Consultation Response from: KC Environmental Health (Pollution & Noise Control)		
2023/90793 - Technology House, Dyson Wood Way, Bradley, Huddersfield, HD2 1GN		
Change of Use from technical development/storage area with 2 storey office to Use Class F1 Learning and Non-Residential Institution		
Responding Date: 30 March 2023	Responding Officer: Mohammed Nasim	Responding Ref: WK202307671
<u>Comments</u> <u>Noise</u> The applicant has submitted a Noise Impact Assessment authored by SLR dated February 2023 Ref 403.000017.00002. It considers the impacts associated with the proposal and the creation of educational use at the Site. Reference is made to the previously approved application (2021/90714) at Salus House, Dyson Wood Way which has been viewed as similar in nature to existing F1 Class use development in the immediate area and this is accepted. A baseline noise survey was undertaken over weekday and weekend periods between Thursday the 15th and Monday the 19th of December 2022 from a single monitoring position as shown in figure 4.1. This was deemed to be appropriate to the nearest noise sensitive receptor (NSR) being 333 Bradley Road at 39m from the existing industrial building

Site Plan 1:250

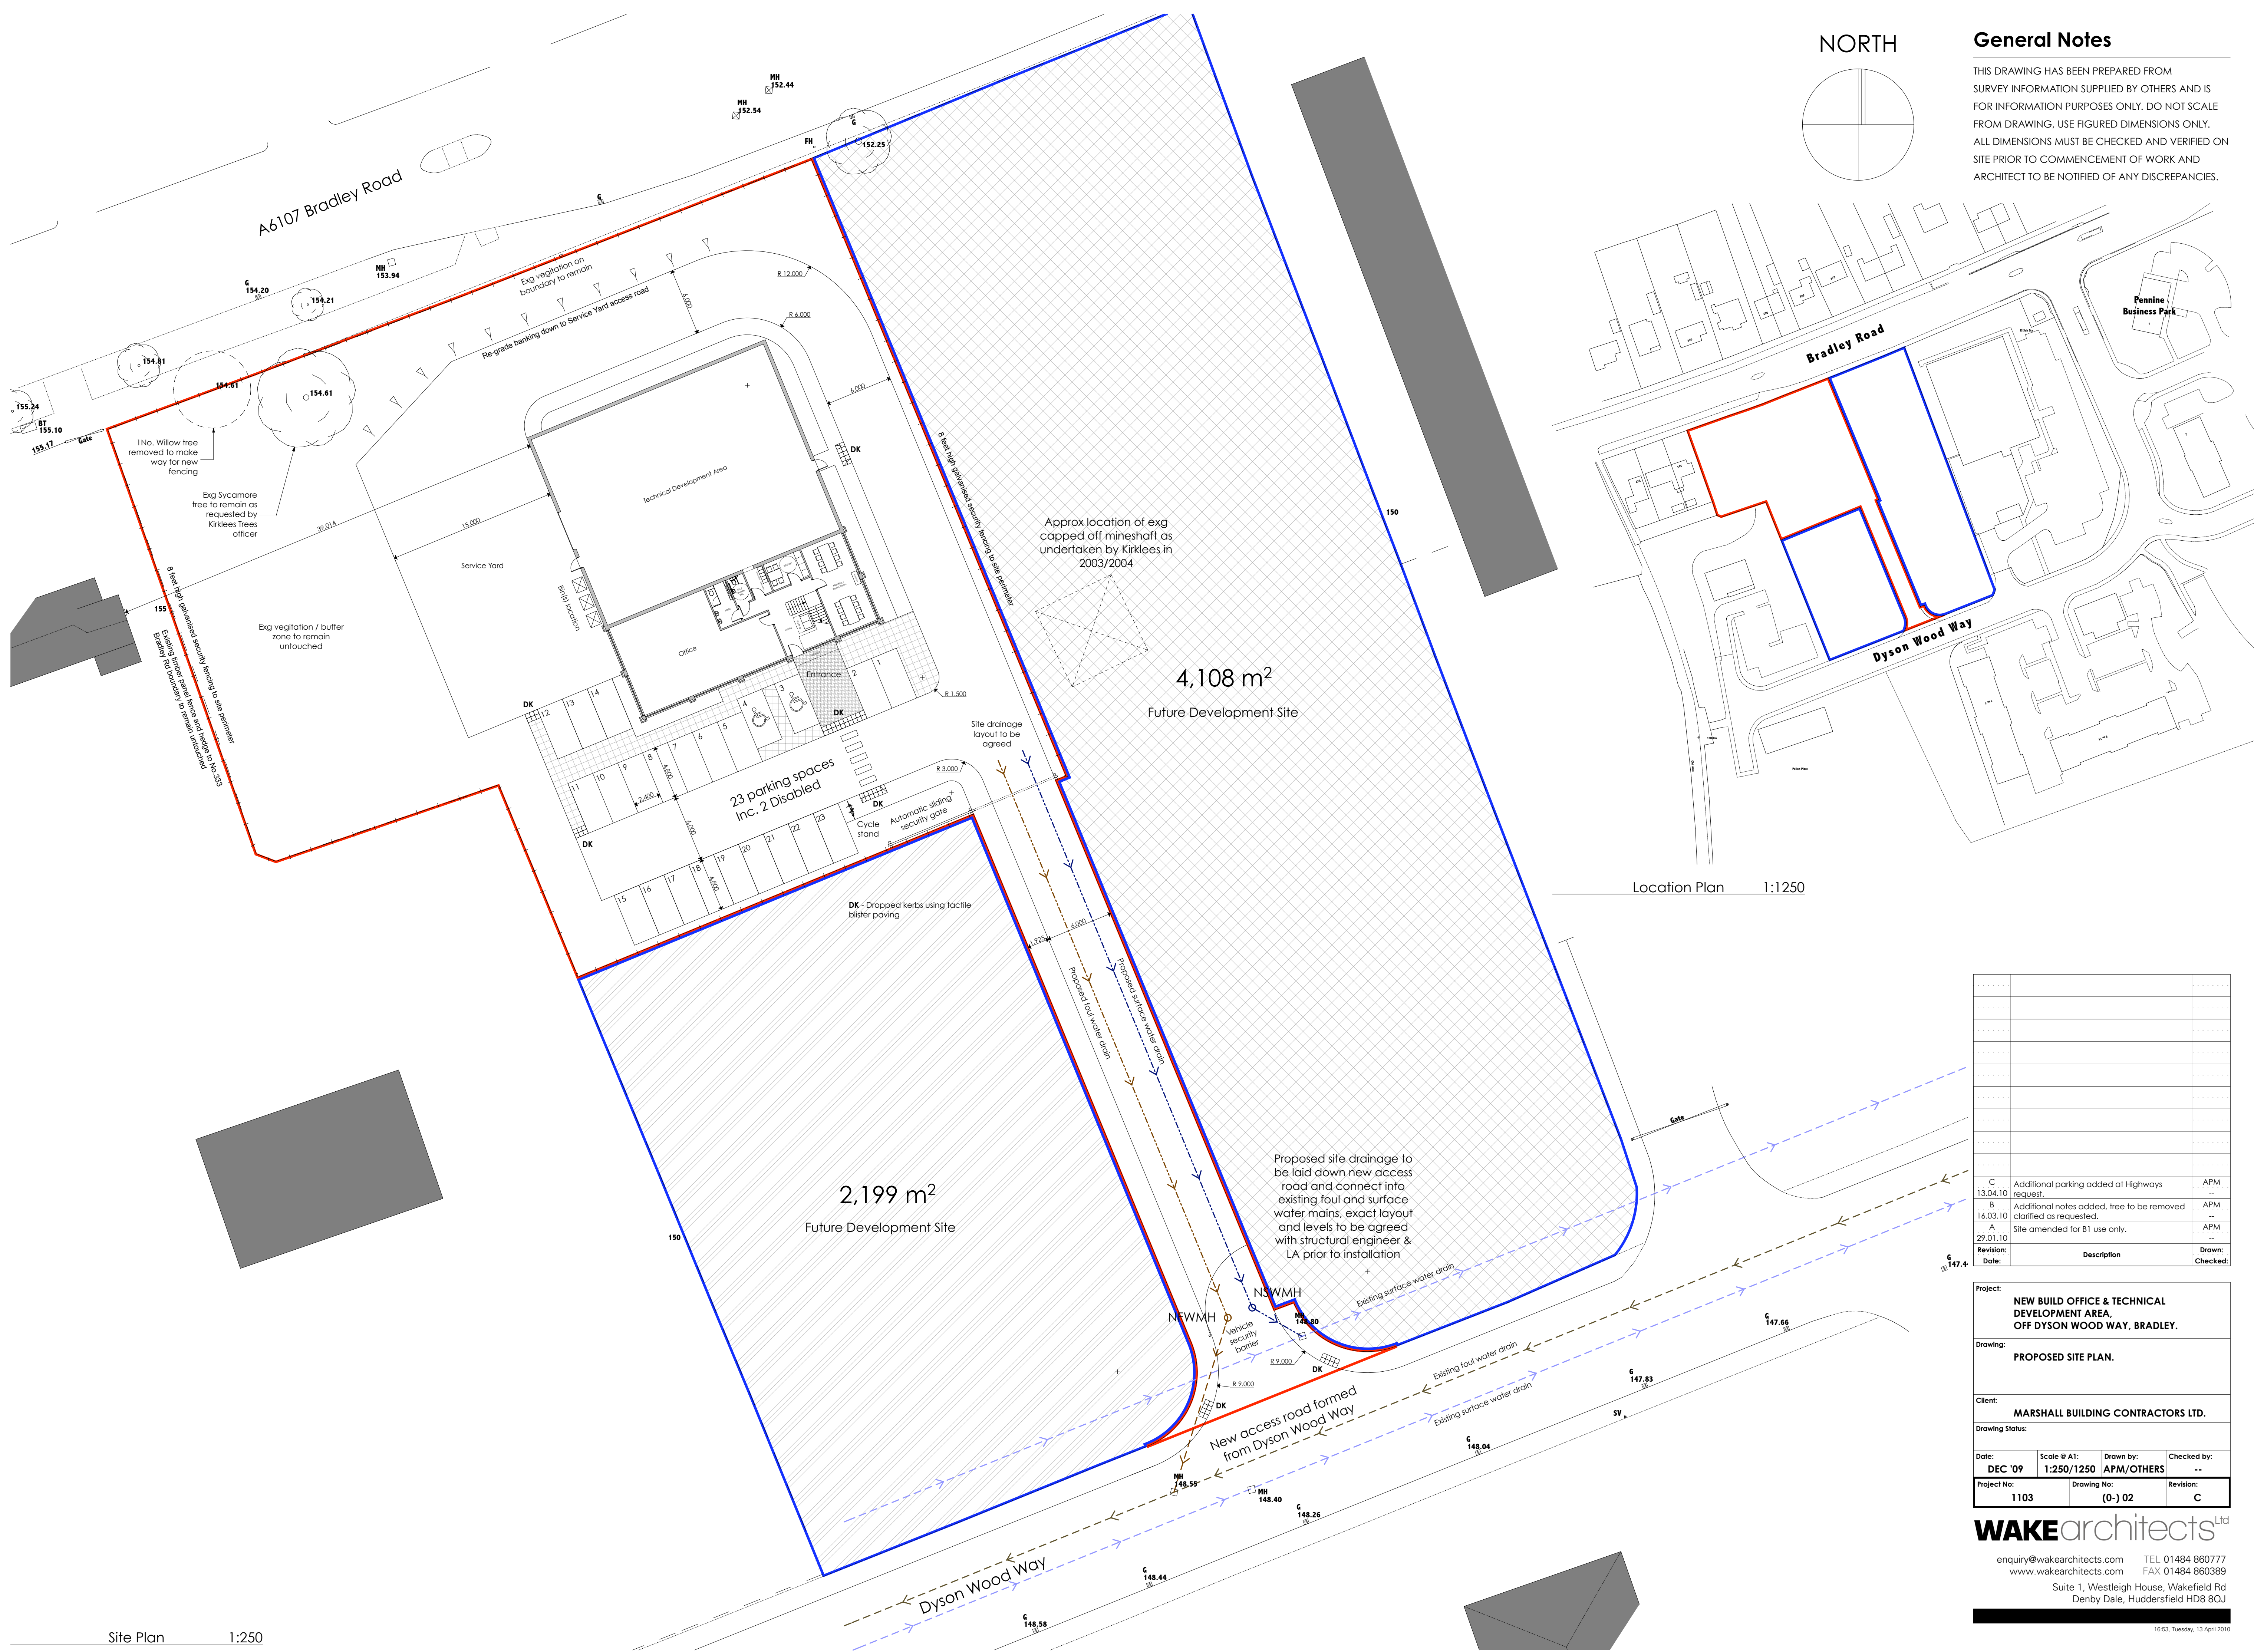
It is unclear if the parking provision is to remain as per the original site plan as shown in the drawing from Wake Architects dated December 2009. In an application of this nature, it is expected that facilities for charging electric vehicles and other ultra-low emission vehicles are provided in accordance with the National Planning Policy Framework and *Air Quality & Emissions Technical Planning Guidance* from the West Yorkshire Low Emissions Strategy Group. A condition requiring charging points is therefore necessary.

EVC1 Electric Vehicle Charging Points - Condition

Before the electrical system is installed, a scheme detailing the dedicated facilities that will be provided for charging electric vehicles and other ultra-low emission vehicles shall be submitted to and approved in writing by the Local Planning Authority. The scheme shall meet at least the following minimum standard for numbers and power output:

- One Standard Electric Vehicle Charging Point providing a continuous supply of at least 16A (3.5kW) for at least 10% of non-residential parking spaces
- For developments where some or all of the parking is likely to be used for shorter stay parking (30mins to 4 hours) Fast (7-23kW) or Rapid (43kW+) charging points will be more appropriate. If Fast or Rapid charging points are proposed together with restrictions on the times that vehicles are allowed to be parked at these points, then a lower number of charging points may be acceptable.
